COUNTY COUNCIL'S RESPONSE TO CONSULTATION ON THE FOLLOWING DEVELOPMENT PROPOSAL

Application no: 19/01047/OUT

Proposal: Outline planning application for a residential development of up to 850 dwellings; green infrastructure including formal (playing fields with changing rooms, allotments) and informal open space, landscaping; and associated infrastructure including a balancing pond; on land off the A4260, with access off the existing Longford Park access off the A4260 (Oxford Road), and a new access off the A4260 (Banbury Road). All matters of detail reserved, save for access.

Response date: 7th August 2019

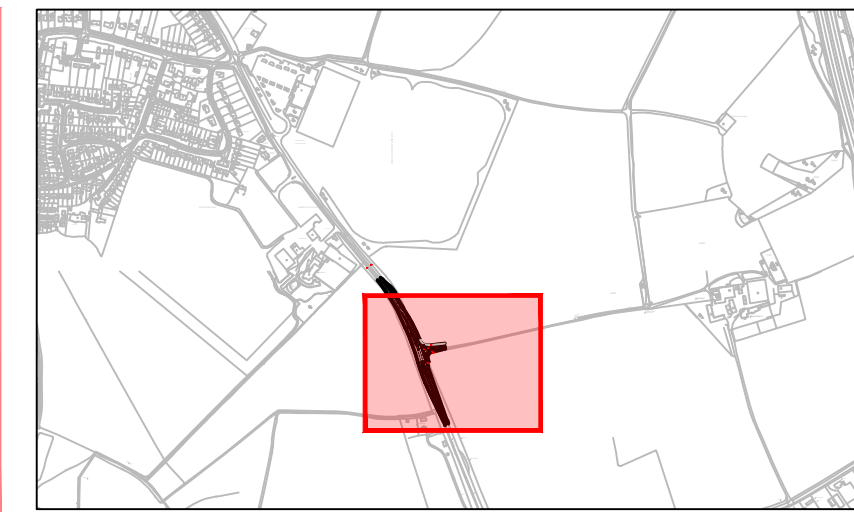
The drawing submitted with the application (16052-01-124 Rev B) does not show visibility splays at this junction, nor forward visibility to the traffic signal heads on the approaches to the junction. This is particularly important given the bend in the road and changes in vertical alignment of the A4260 just to the west of the junction.

The length of the required visibility splay at the site access and of the forward visibility to the signal heads must be informed by the current 85th percentile speeds at this location, in accordance with standards set out in the DMRB. This must be based on current traffic speeds as the TRO required for the extension to the 40mph restriction will be subject to statutory consultation and so cannot be predetermined. Vehicle tracking for coaches, large refuge vehicles and emergency vehicles making turning movements to / from the access junction in all directions is required to demonstrate that these vehicles can safely access the site at this junction.
